About the application

Application number: 2019/92221	
What is the application for?:	Outline application for demolition of existing buildings and erection of Class
Address of the site or building:	Kenmore Caravans Ltd, 119, Huddersfield Road, Mirfield, WF14 9DA
Postcode:	WA8 8PU

Type of comment: An objection

**Proposed Development
Huddersfield Road.
Mirfield.
Site Layout and Access
Arrangements**

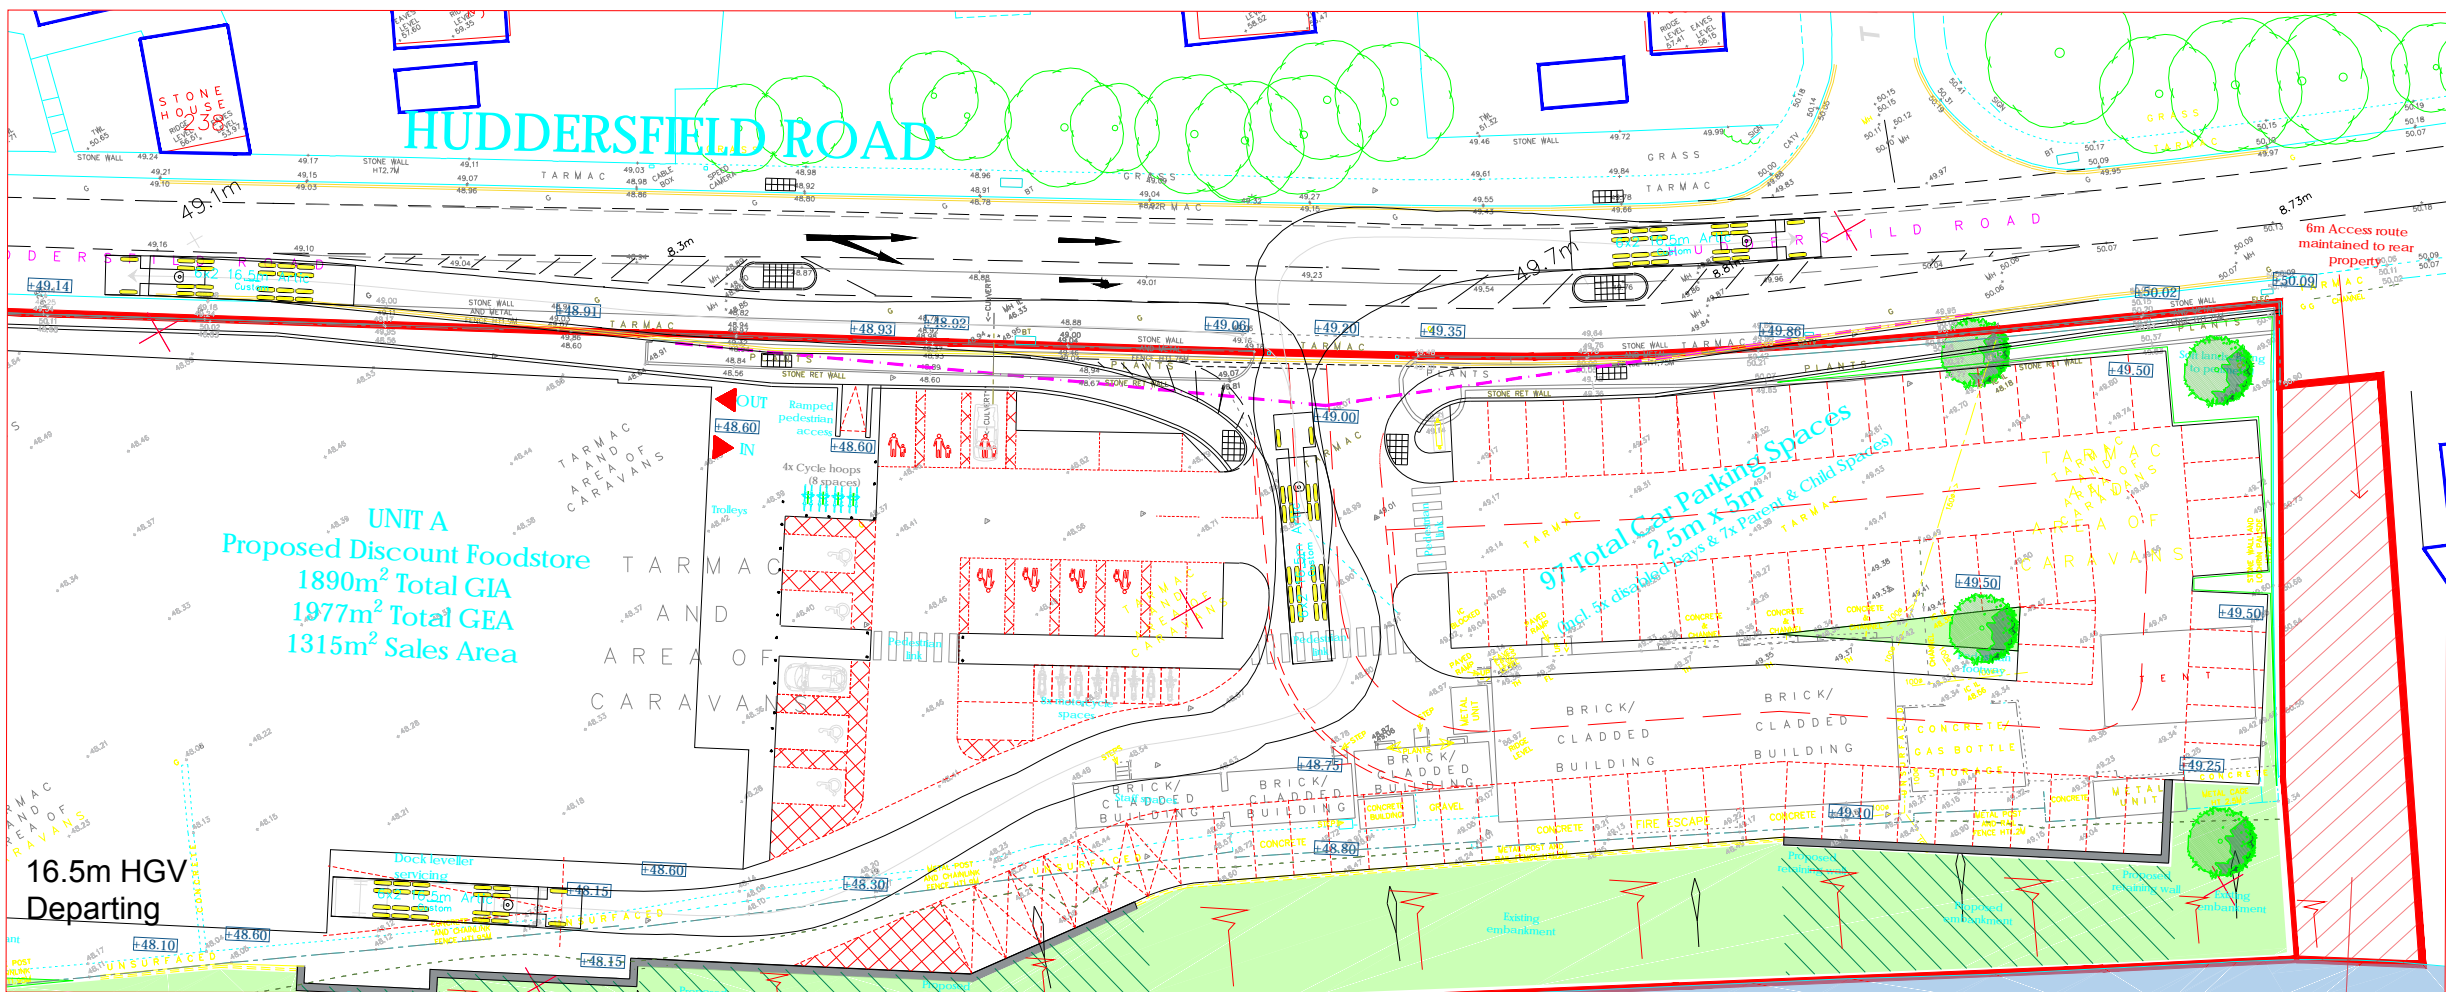
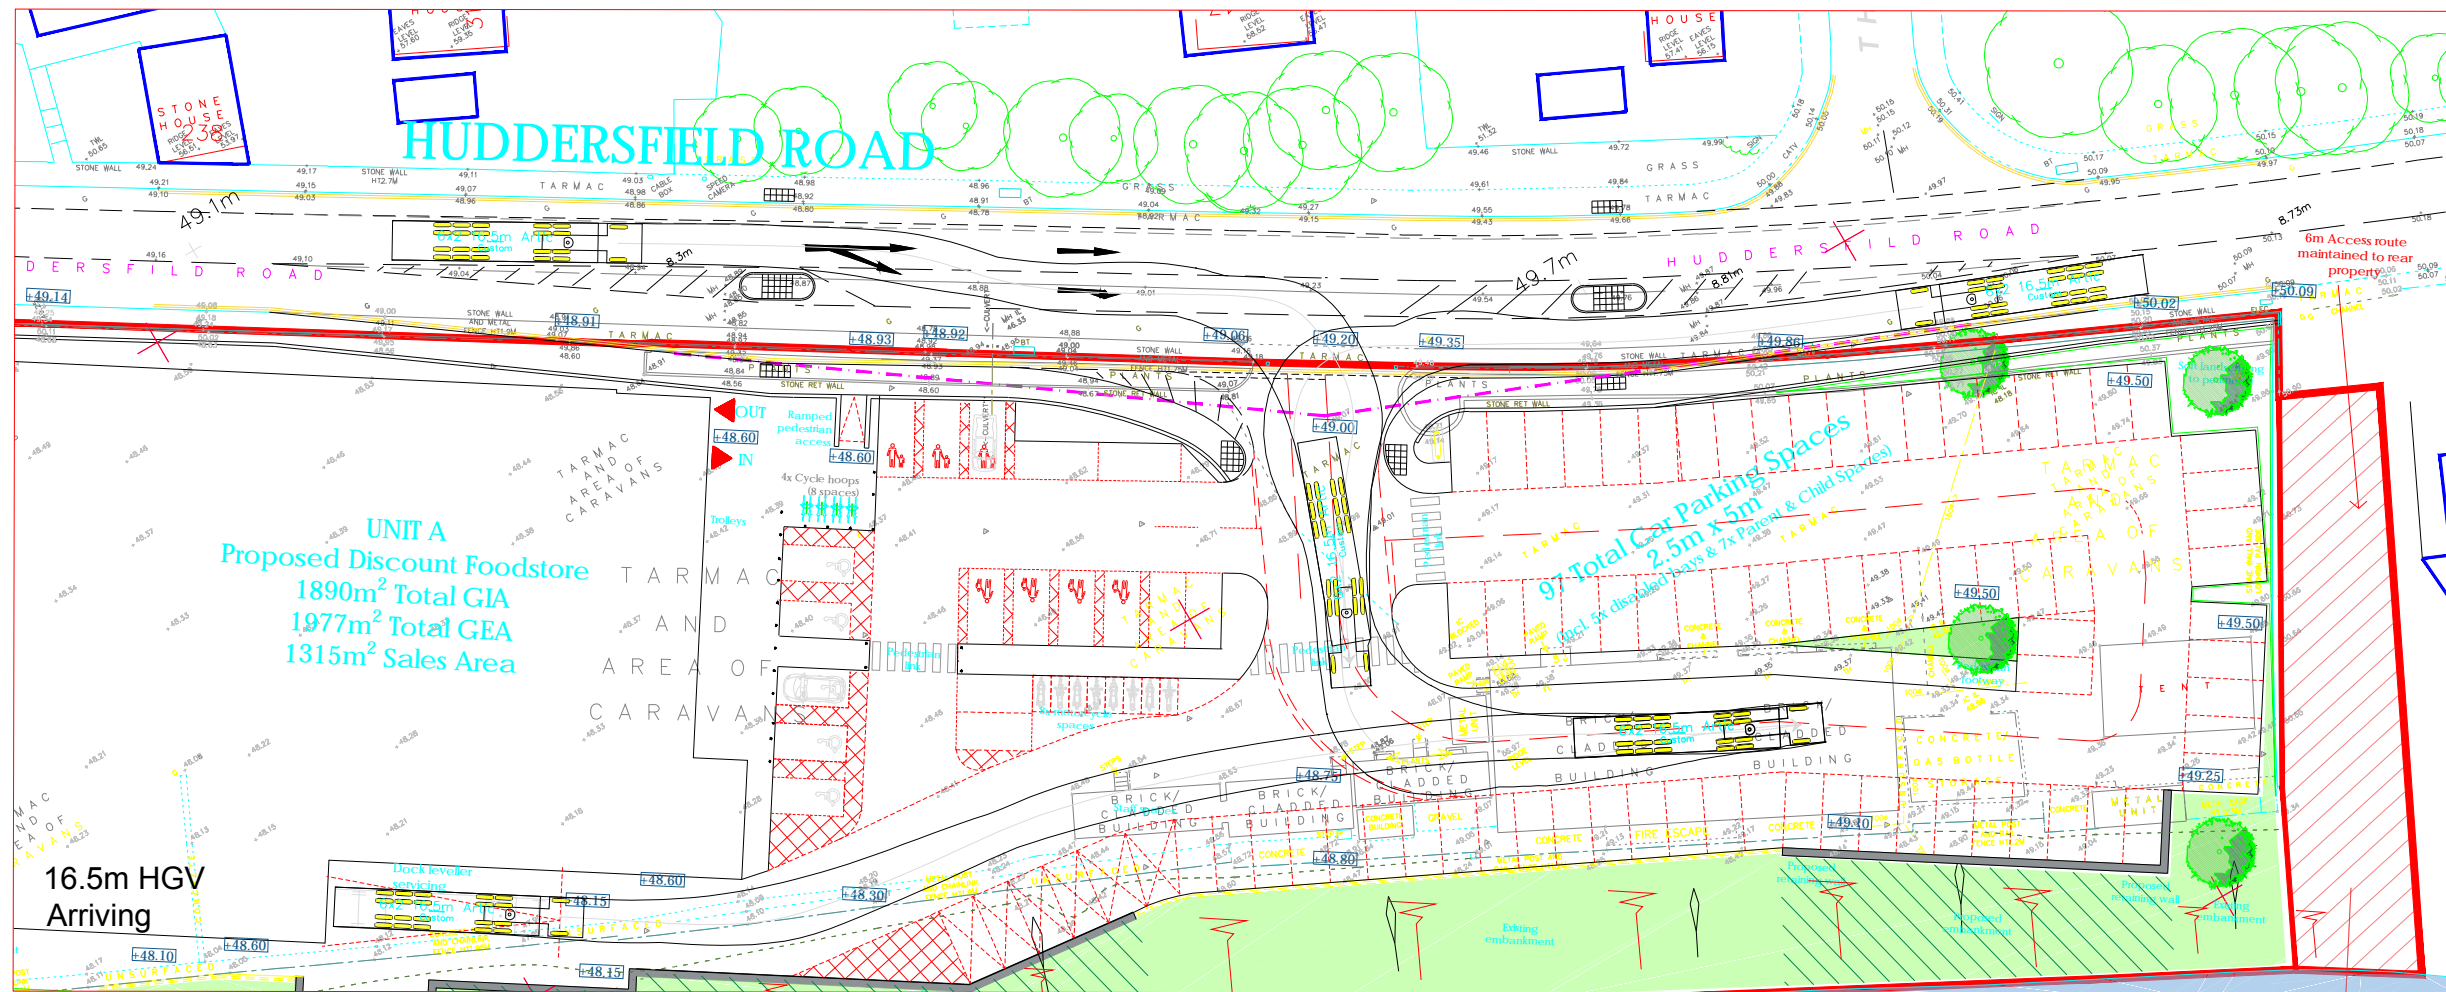
1. Huddersfield Road is a very busy road at all times and has a 40mph speed limit at the proposed car park entrance /exit. It is a single carriageway in both directions and has a cycle lane flowing eastbound. It is regularly used by all emergency services and is an alternative route when the M62 motorway is closed. There are two bus stops close to the proposed entrance / exit which will bring traffic to a standstill as passengers board and alight.

3. Right turning traffic approaching the site from Huddersfield will be stranded in the middle of the road with traffic approaching eastbound and westbound at 40mph

4. Right turning traffic egressing the proposed car park will have difficulty exiting, causing potential gridlock in the car park

6. The staggered junction with The Maltings will be a very difficult junction to negotiate and increase the potential for accidents

7. The walking catchment area will predominantly come from the north of the development. There appear to be no plans for a pedestrian refuge when crossing Huddersfield Road
